From: Simon Davis
Sent: 16 July 2021 13:20
To: [REDACTED]
Subject: RE: RE: P/84/21/DOC Inglenook (Drainage)

Condition 6- surface water drainage design

Condition 7- maintenance and management of surface water drainage

Drawing Title: **Proposed Levels & Contours
Sheet 2 of 2**

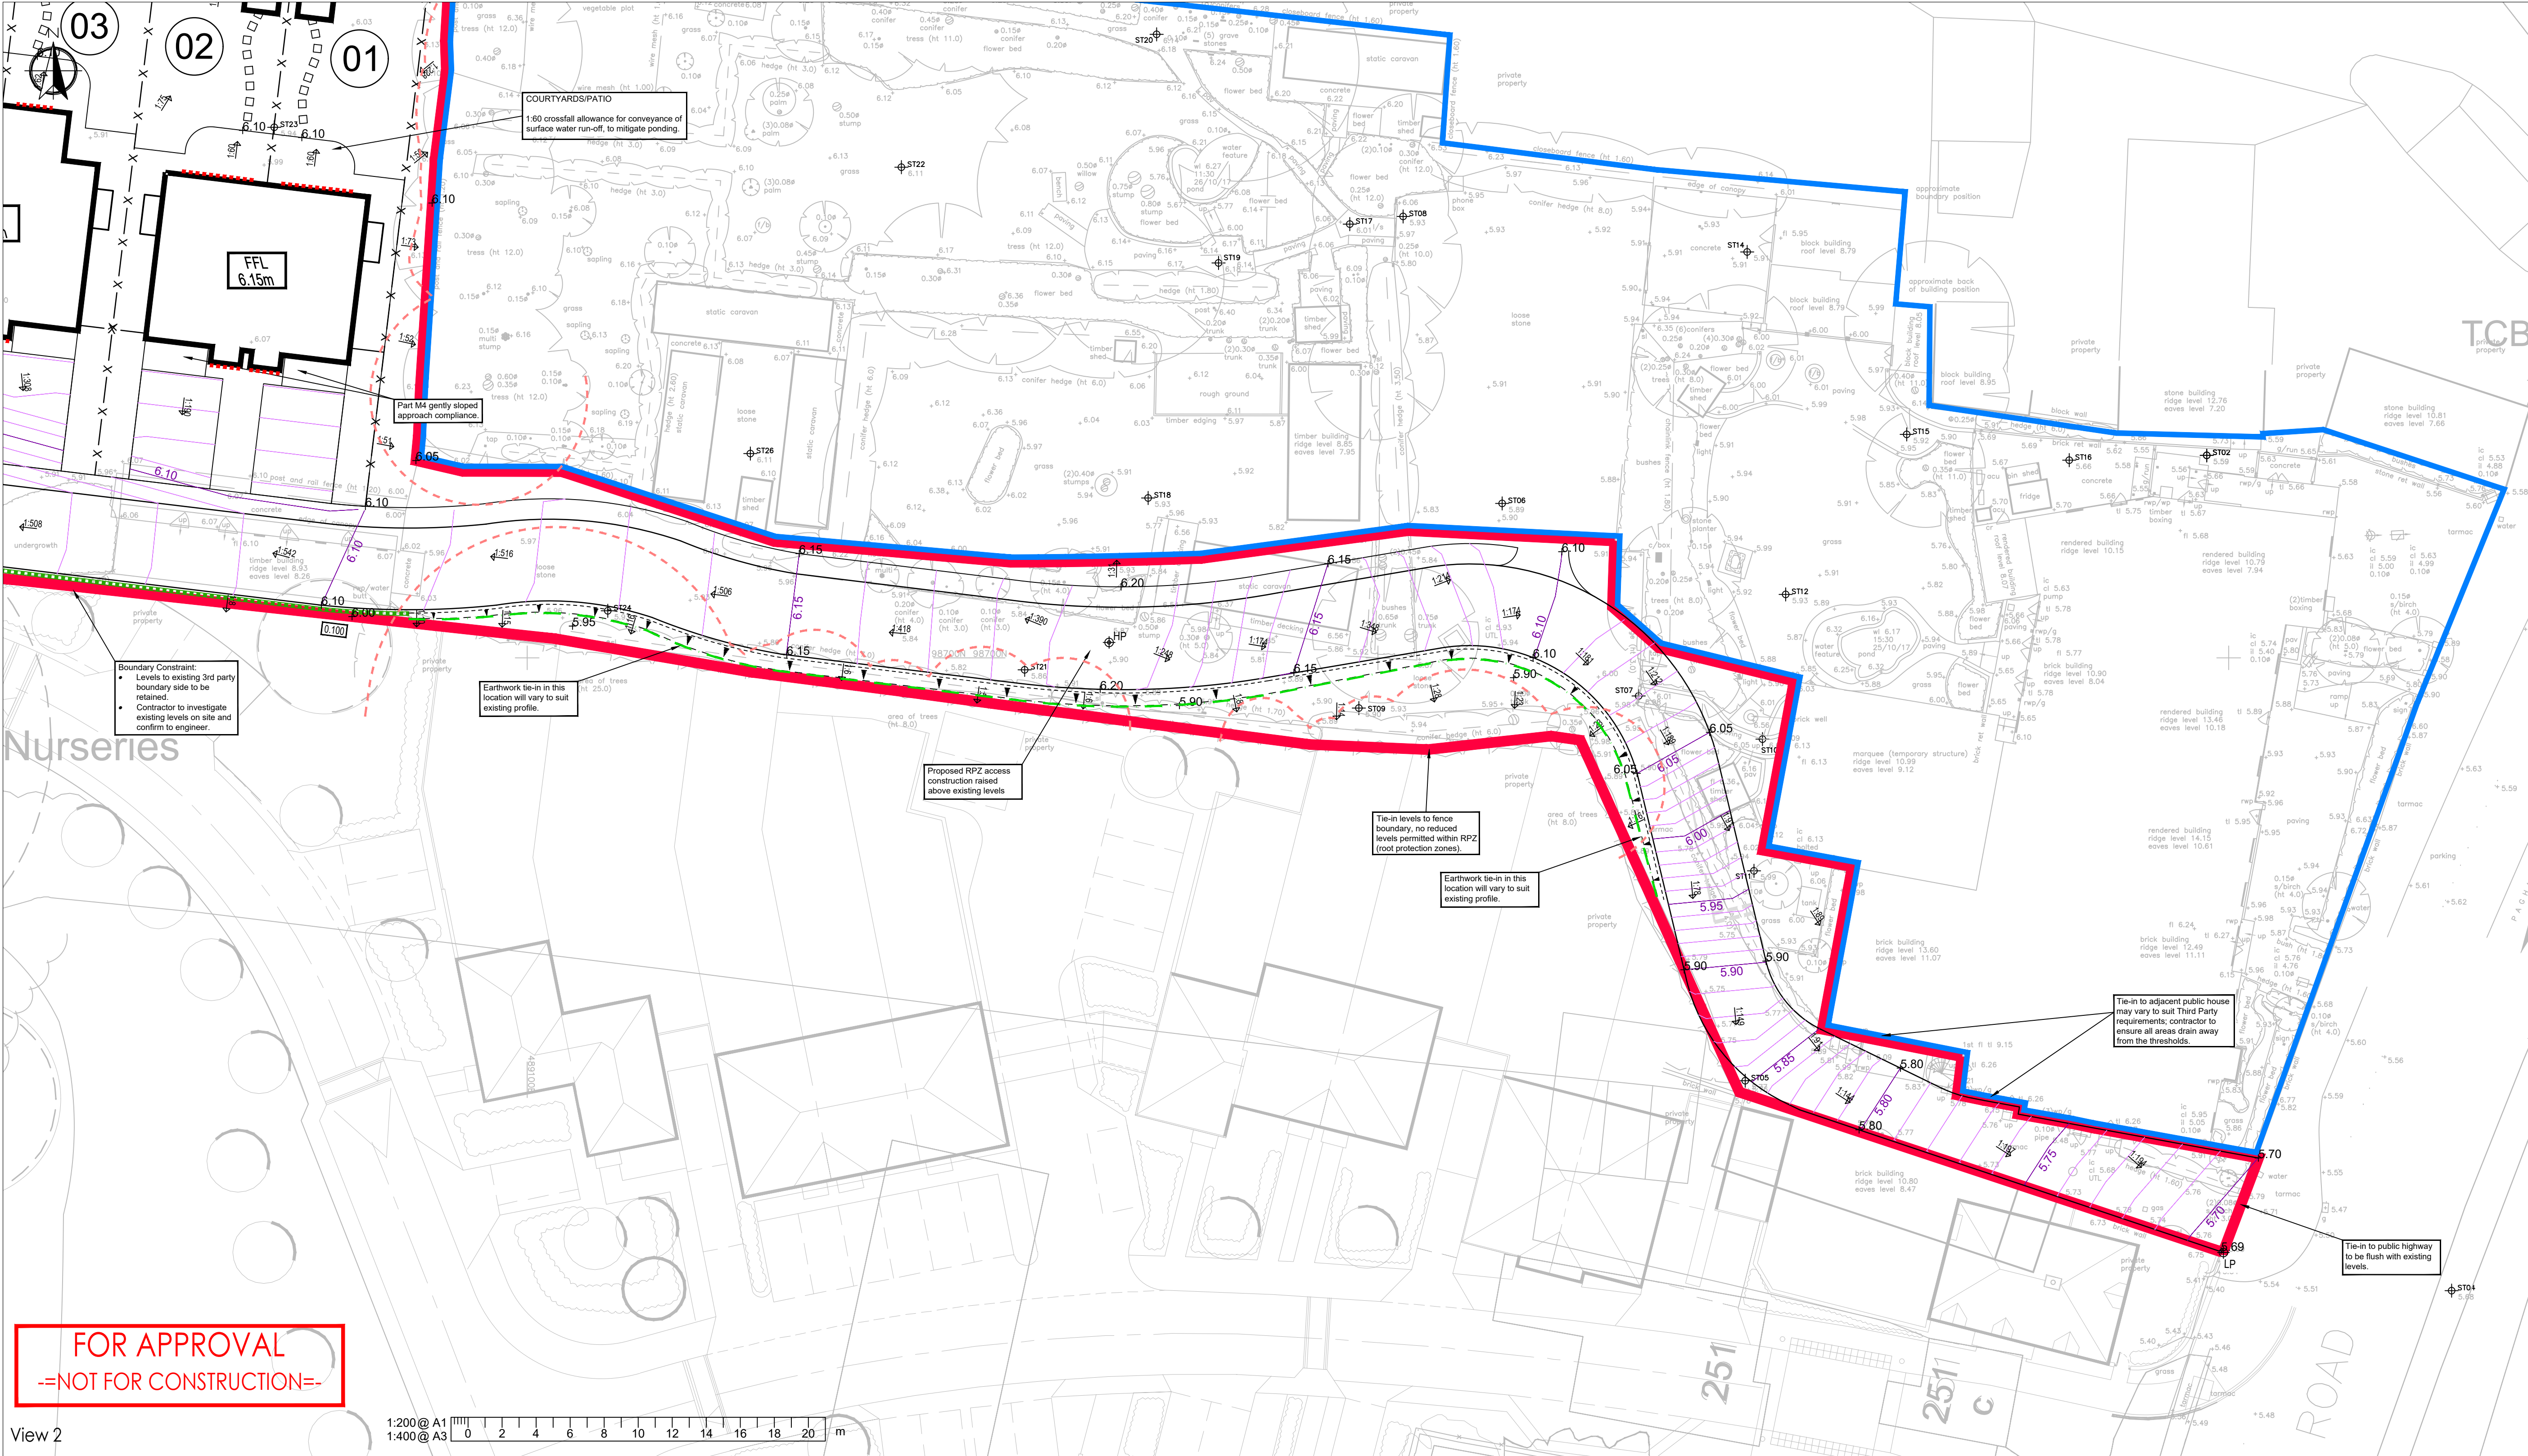
9 – The levels look fine to me but I am just checking with the drainage engineer whether it is ok to agree these before the drainage is agreed.

Drawing Status	FOR APPROVAL						
Client	Future Group Development Ltd						
Project	Land at The Inglenook Pagham Road, Bognor Regis PO21 3QB						
Drawing Title	Proposed Drainage Arrangement Sheet 2 of 2						
Scale	1:200	Date	May 2021	Drawn By	DJL	Checked By	MJA
Drawing No.	D1966-103.2	Rev.	-

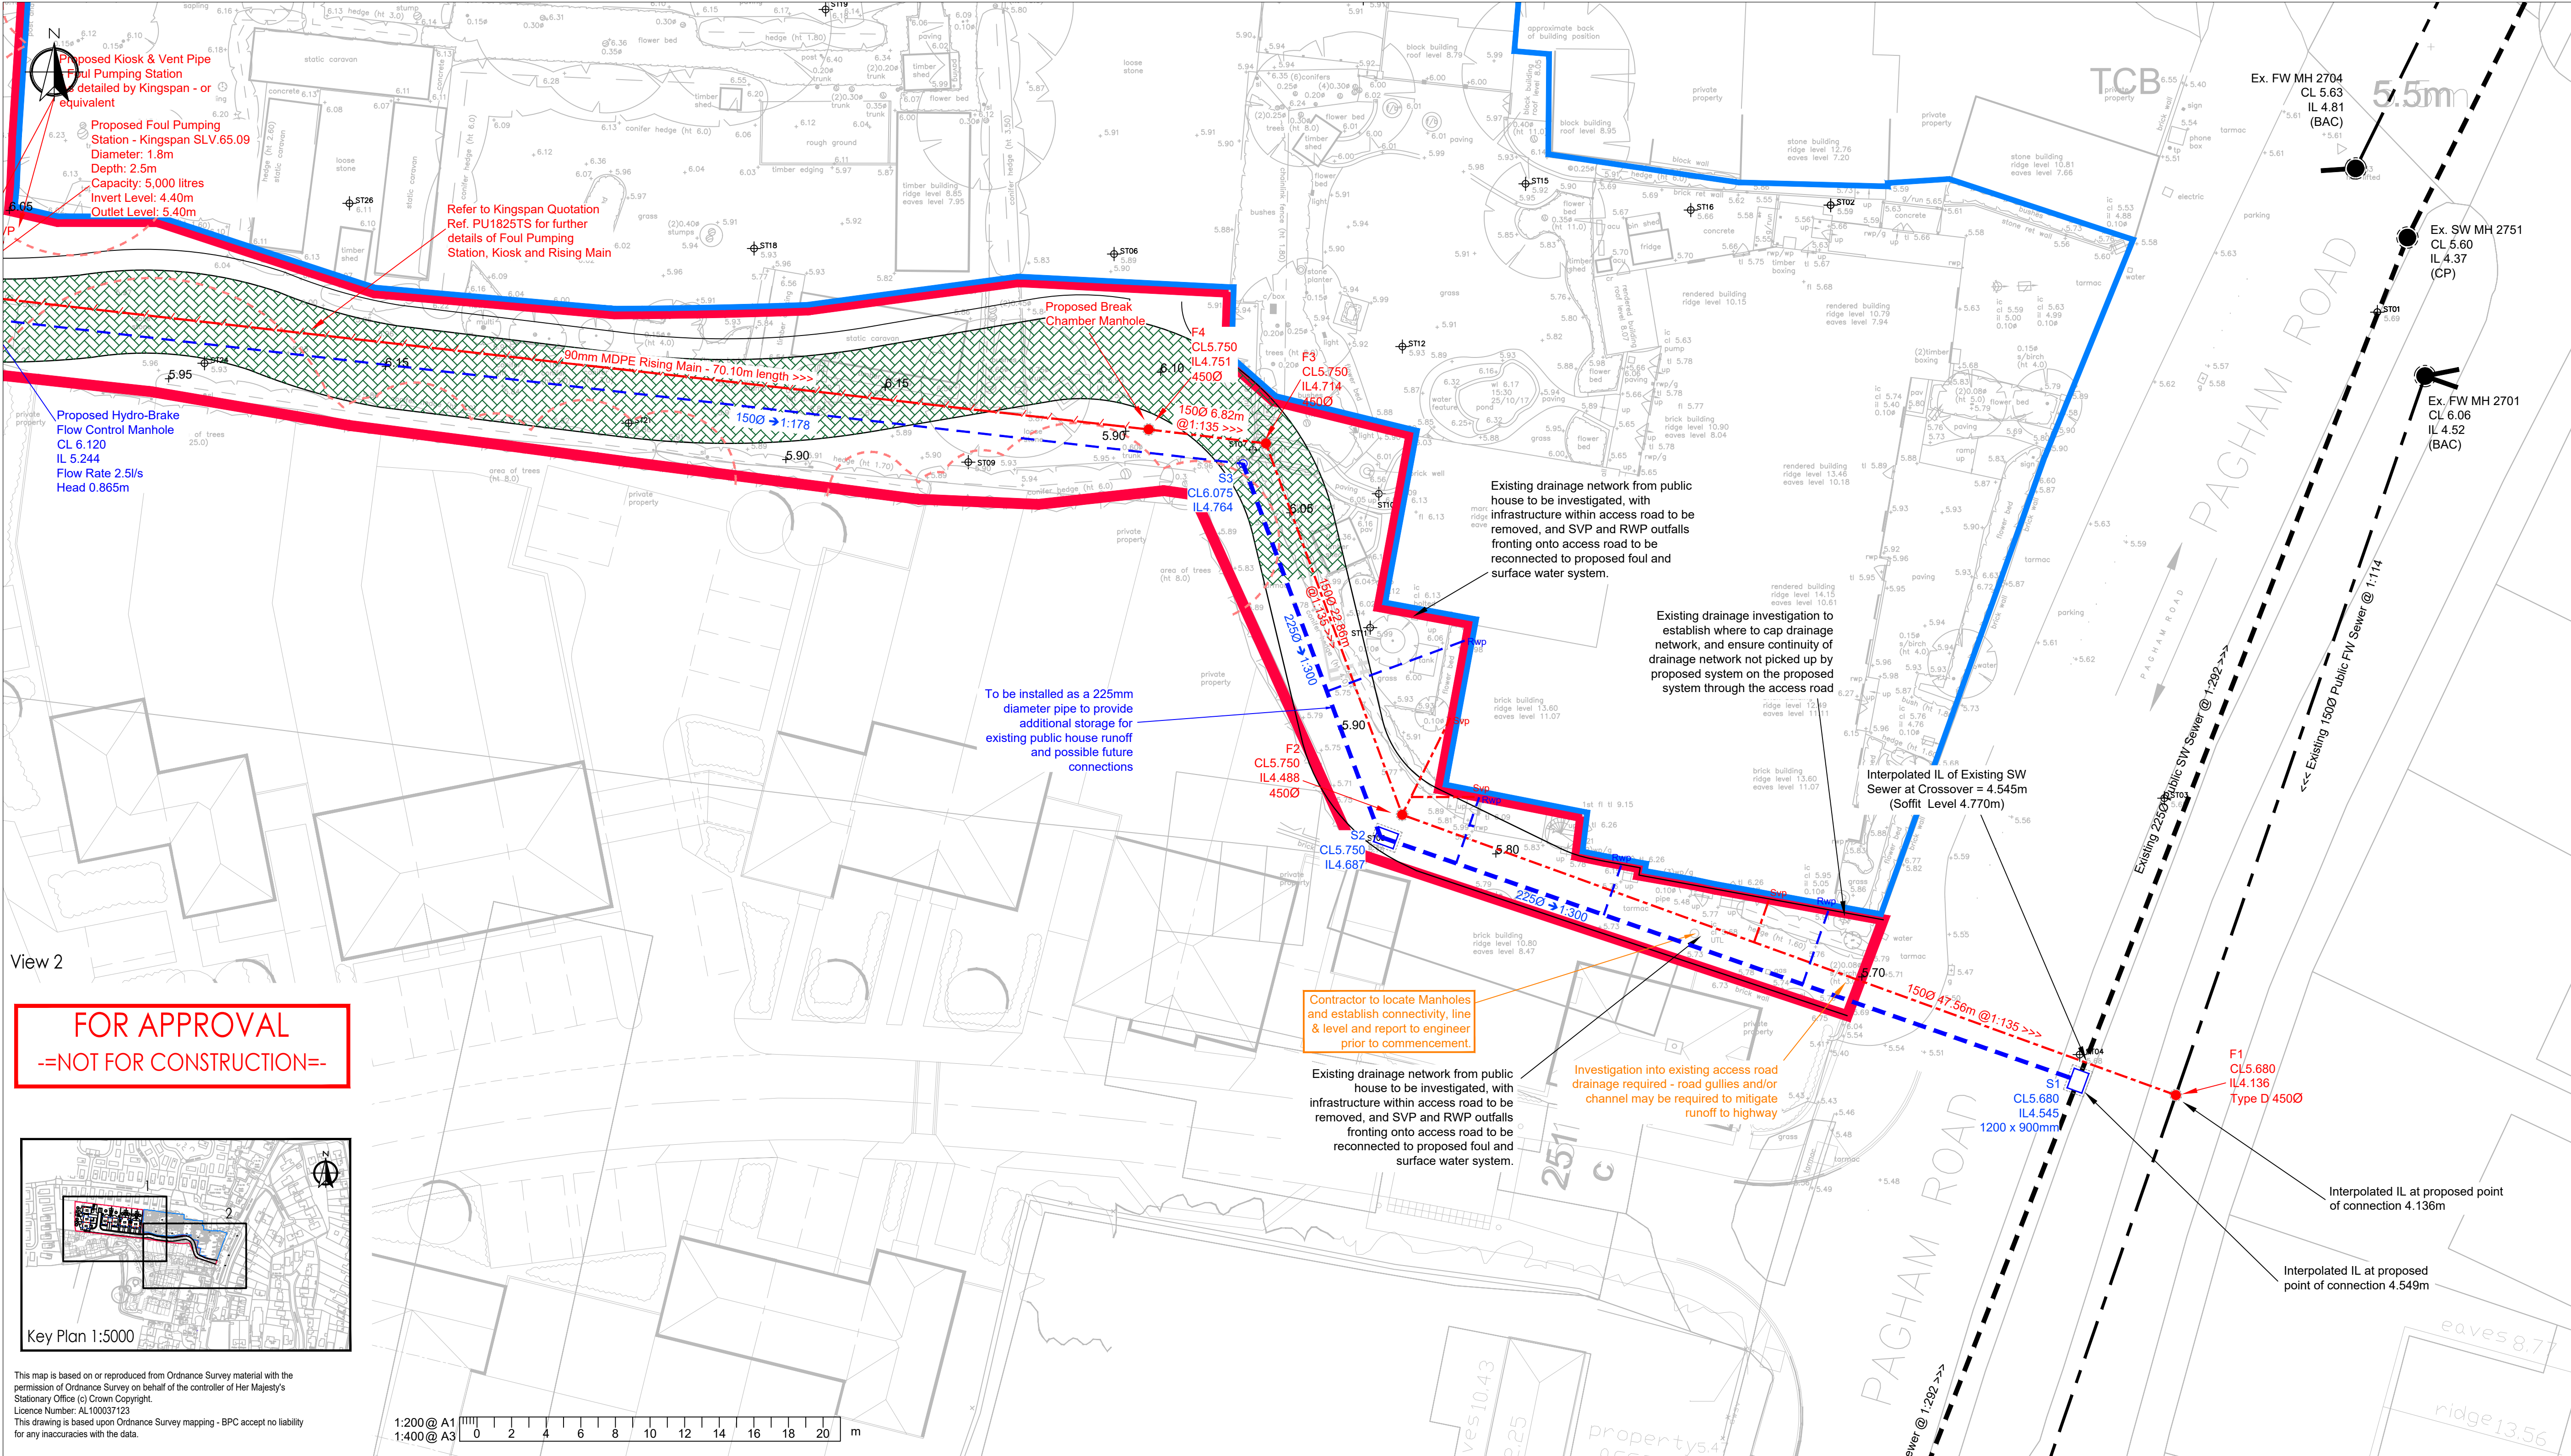
4. Please detail formation level of permeable paving on plans.

5. Please state hydrobrake reference on both layout and construction detail.

Please see revised drawing. These are detailed accordingly.

Please see revised drawings.

FLOW CONTROL CHAMBER
(Scale 1:20)

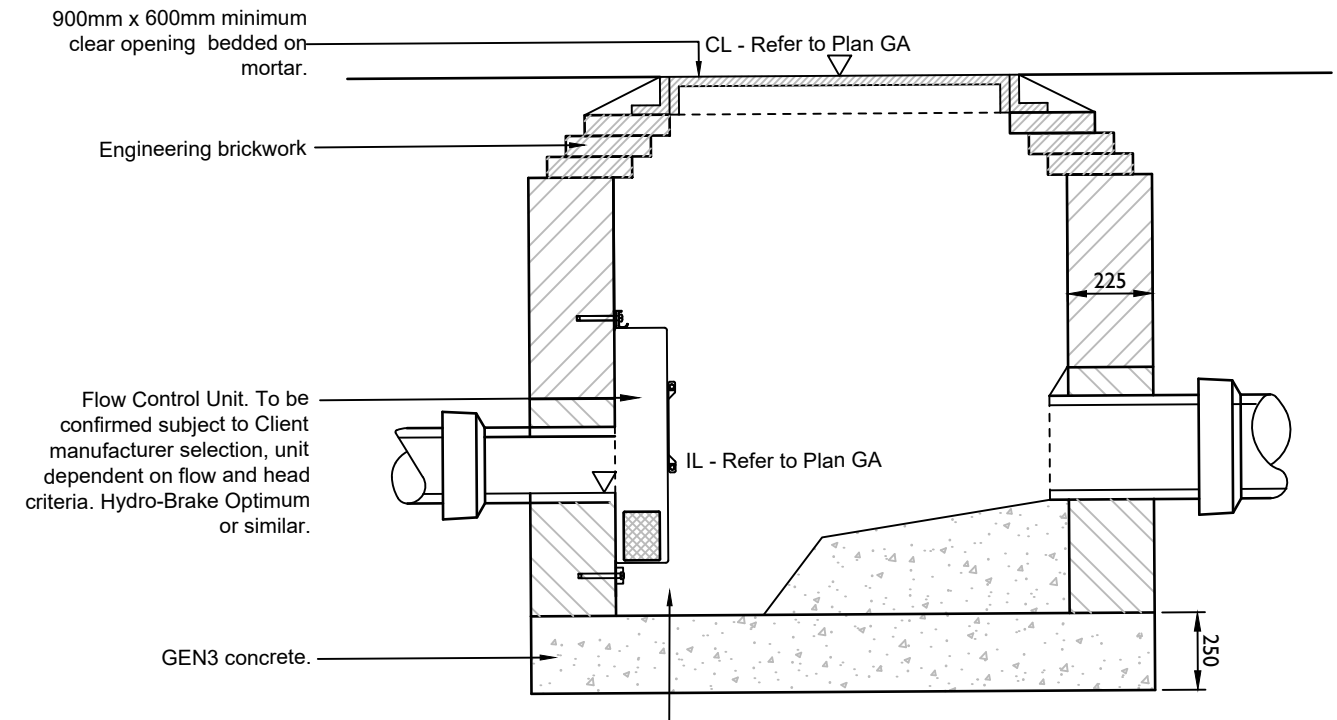
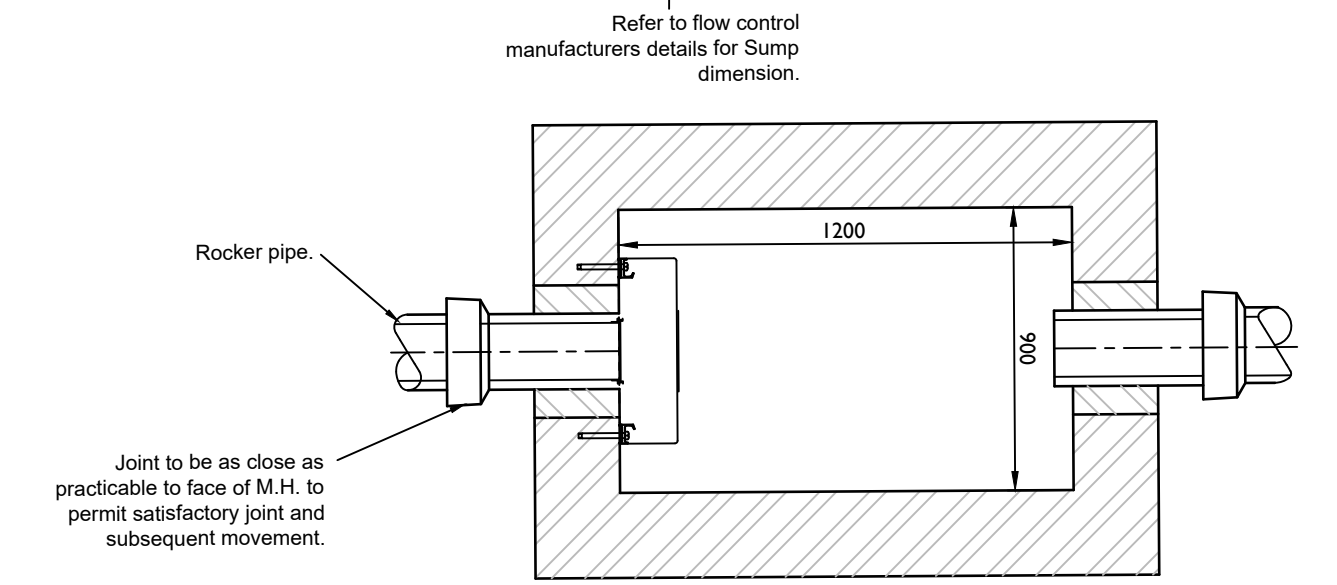
6. Please show hydrobrake bypass door, operating rope and fixing and construction detail.

Please see detail, with unit specified. Not required for shallow chambers, in accordance with manufacturer's recommendations. Invert is <1.0m from cover level -- can be accessed by hand from ground level for clearance & emergency maintenance.
